RE: Northside Mental Health Facility, St Leonards (SSD 7588), Response to submissions – Architectural components

Formal response –

1 ELEVATION WEST
1:100

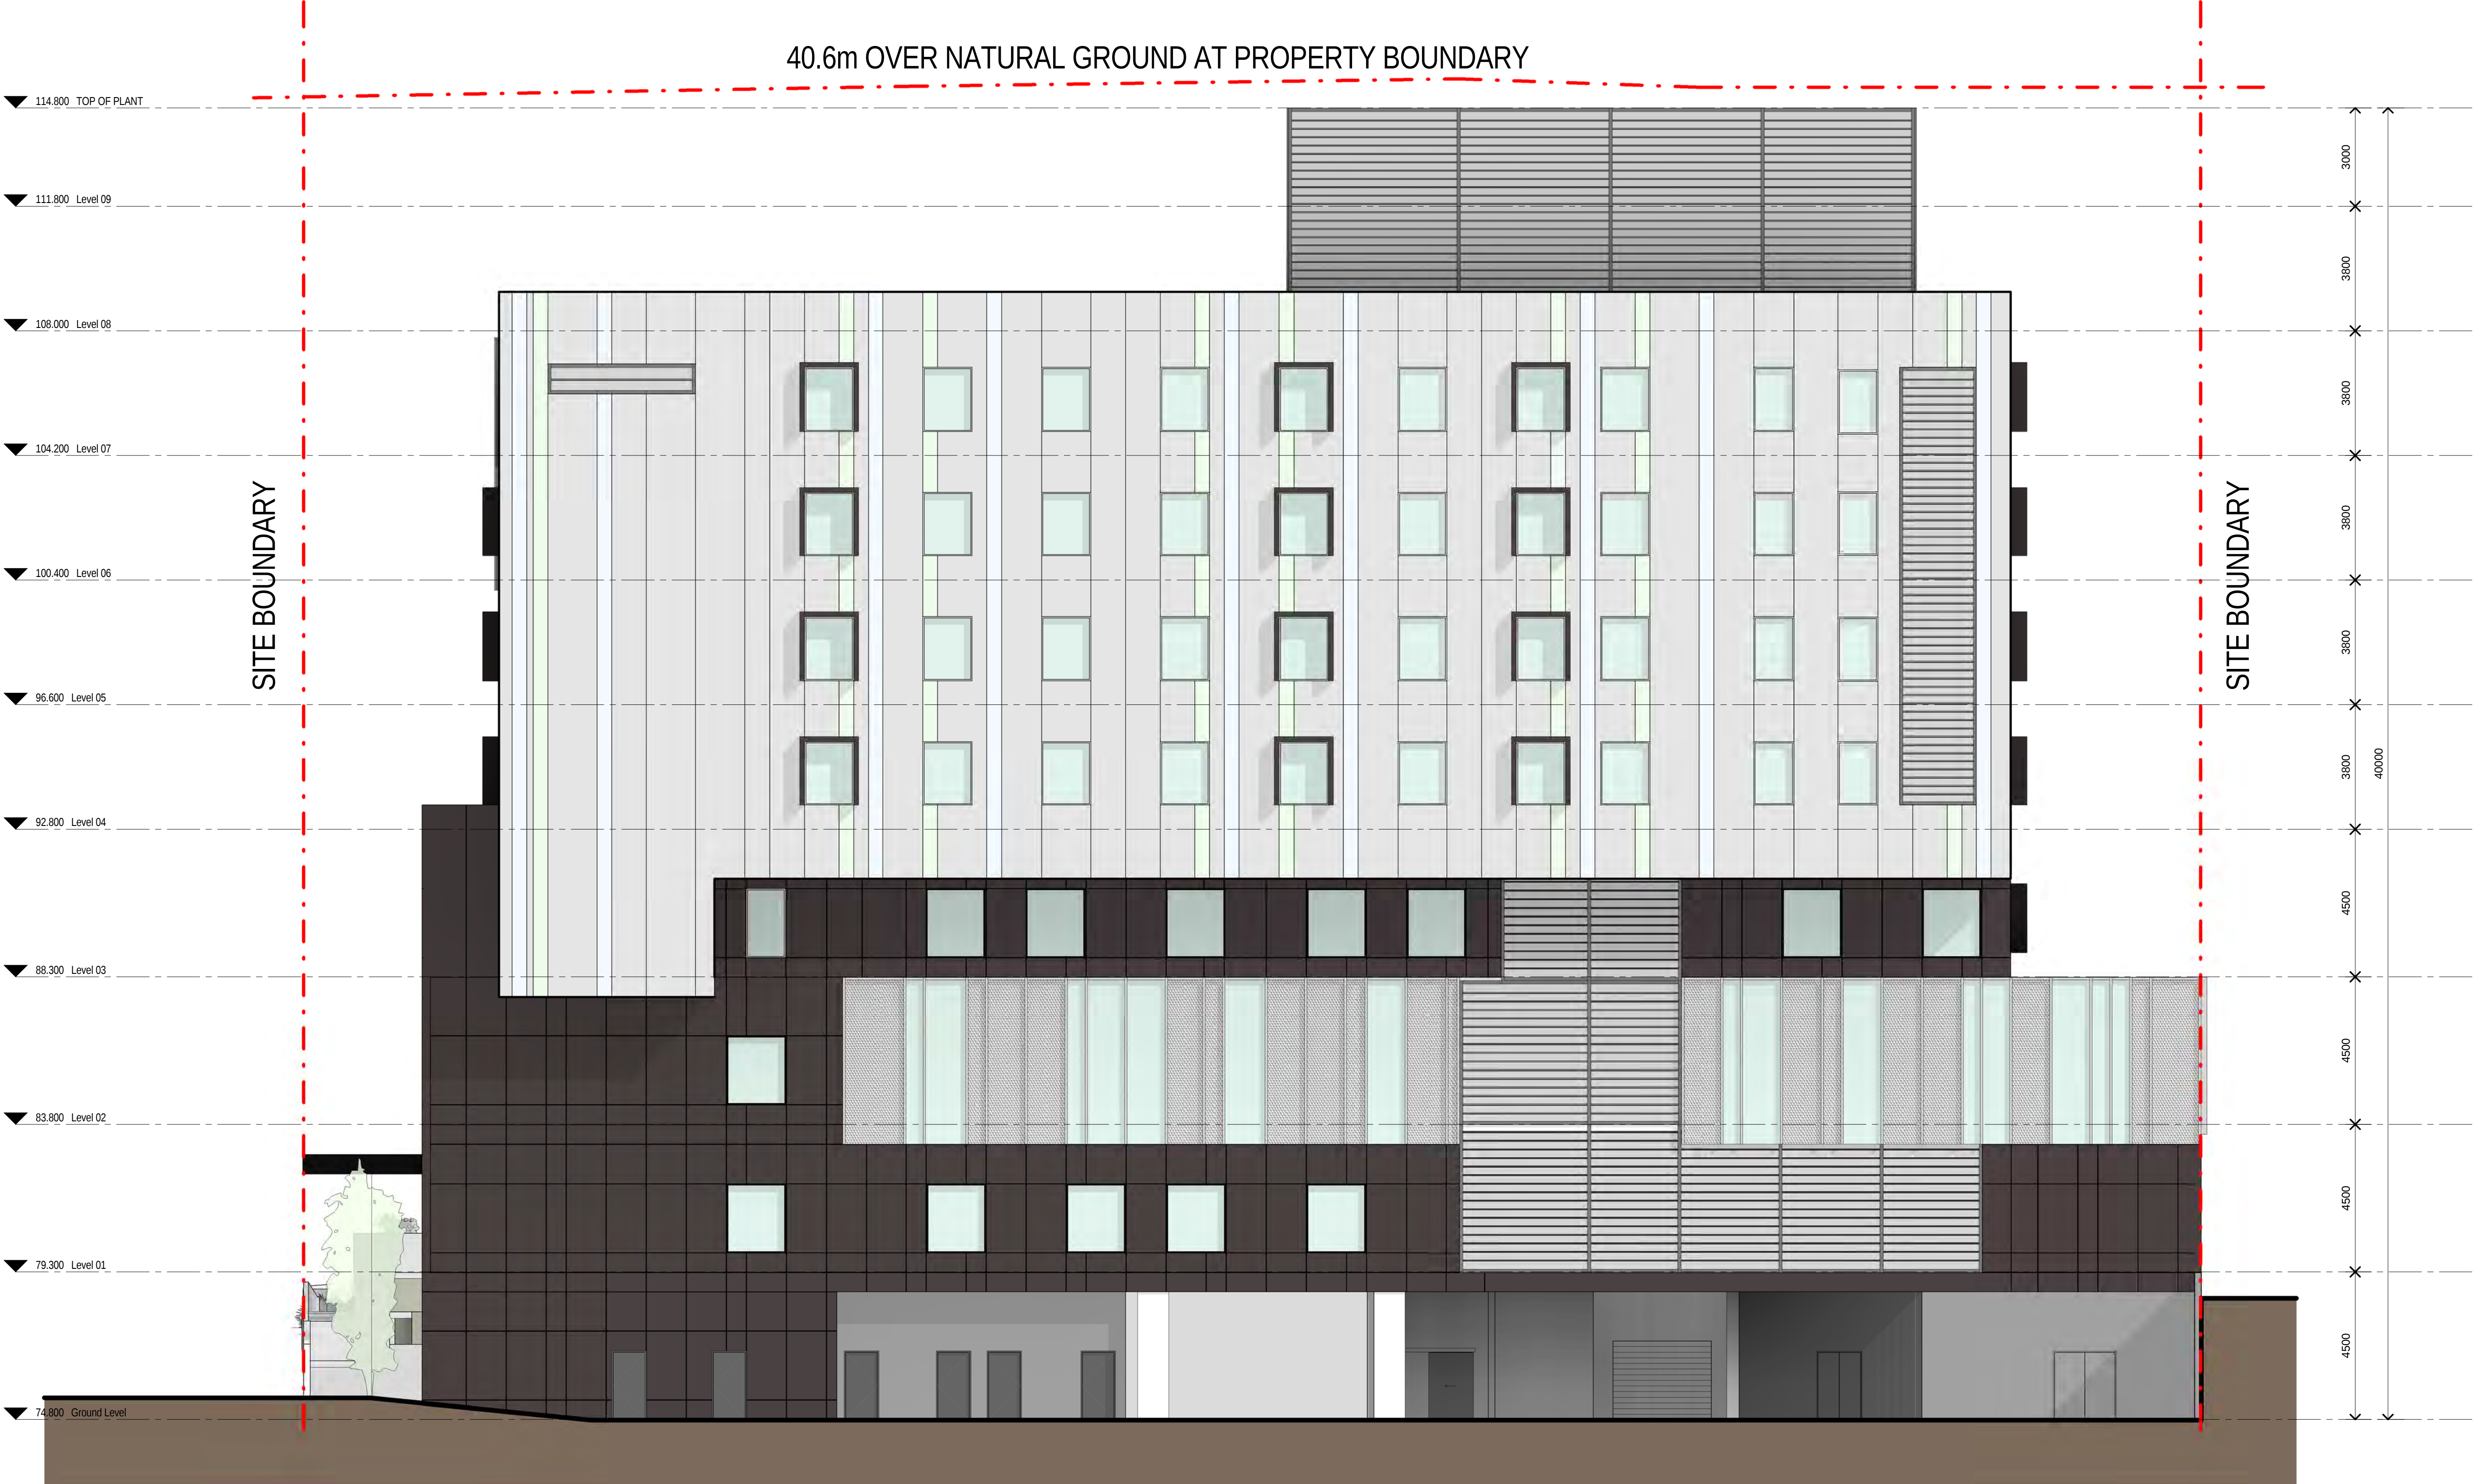
The proposed L-shaped built forms provide a visually interesting forecourt addressing Frederick Street. However, the proposed building has limited setbacks and building modulation along its south-eastern and western elevations. Considerations should be given to a podium - tower treatment to the proposed built forms to allow for a better transition of scale between the proposed building and surrounding developments. A podium level will also provide additional outdoor spaces and improved outlooks and amenity for rooms facing the side and rear elevations over adjoining industrial developments.

In response to above, we note that at the western elevation, the long edge of the 'L shape' is setback approximately 7 metres (the width of the driveway) at the lower levels. This setback reduces to 5 metres on the upper ward levels (Level 4 and above); whilst this is comparatively less articulation compared to the more prominent northern and eastern edge, it's appropriate given the relatively low adjacency and exposure to Frederick Street for this façade and the likelihood that the adjacent property to the west may be built out to a similar bulk and scale in the future.
